ADDRESS : 169 MINERAL SPRING LN SUBDIV: AVERY POND 32LOTS  
 CONTRACTOR : WYNN CONSTRUCTION, INC. PHONE : (919) 528-1347  
 OWNER : LITTLE CROSS LLC PHONE :  
 PARCEL : 08-0653- - -0029- -14-  
 APPL NUMBER: 16-50040139 CP NEW RESIDENTIAL (SFD)  
 DIRECTIONS : T/S: 11/10/2016 10:34 AM JBROCK ----  
 AVERY POND #14 OFF OF CHALYBEATE RD

**STRUCTURE: 000 000 60X60 4BDR MONO W/ GARAGE & COV POR**

RE: Engineering - Field Observation  
Lot 14 Avery Pond Subdivision; Fuqua Varina, NC  
Project No.:17DDM-0620C

FOUNDATION LOCATION SURVEY LOT 14  
 "AVERY POND S/D", PHASE - 1

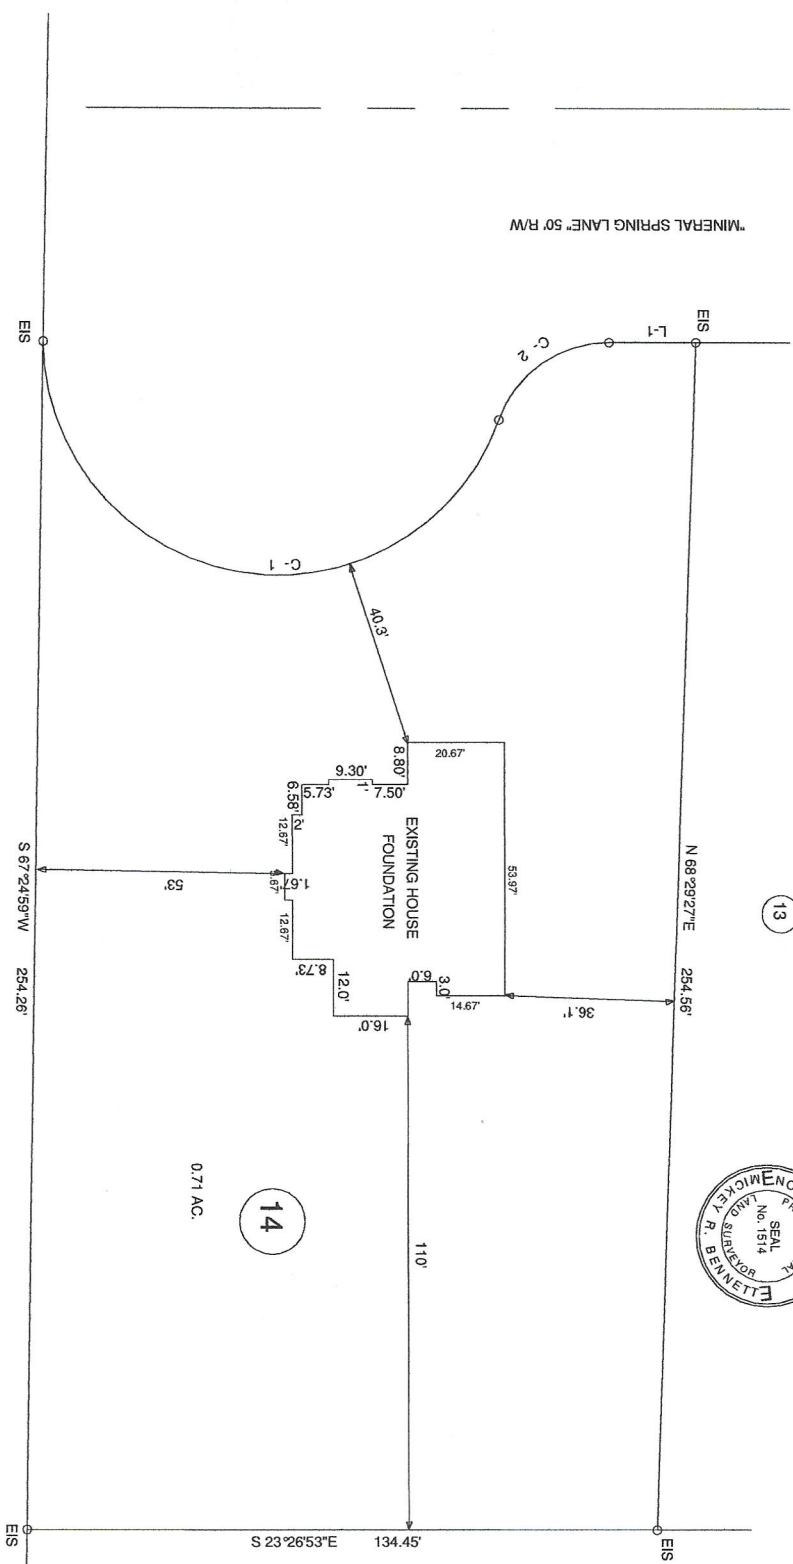
R425 01	6/20/17 6/20/17	BS DA	FOUR TRADE ROUGH IN TIME: 17:00 VRU #: 002986909 T/S: 06/19/2017 03:02 PM BPETRICH ----- T/S: June 20, 2017 01:55 PM BSUTTON ----- 1. Need engineering on right garage wall hanging off of slab. 2. Need nail plate at washer vent top plate.
I129 01	6/26/17 <i>6/26/17</i>	TI <i>ARS</i>	R*INSULATION INSPECTION TIME: 17:00 VRU #: 002989242 T/S: 06/23/2017 02:33 PM BPETRICH -----
R425 02	6/26/17 <i>6/26/17</i>	TI <i>ARS</i>	FOUR TRADE ROUGH IN TIME: 17:00 VRU #: 002989259 T/S: 06/23/2017 02:33 PM BPETRICH -----

The right garage wall was observed to have approximately 1 inch of the load bearing wall to be overhanging approximately 1" over the turned down slab for the B3 roof truss. Based on the loading conditions of the B3 roof truss a 951-lb (475.5 lb/ft) reaction load over 2 feet c/c bears on the wall. Based on the loading conditions the loading was analyzed for the eccentricity in the wall and foundation

~~Observations, measurements, and analysis of the loading conditions on the garage wall  
adequately transferred to the foundation.~~
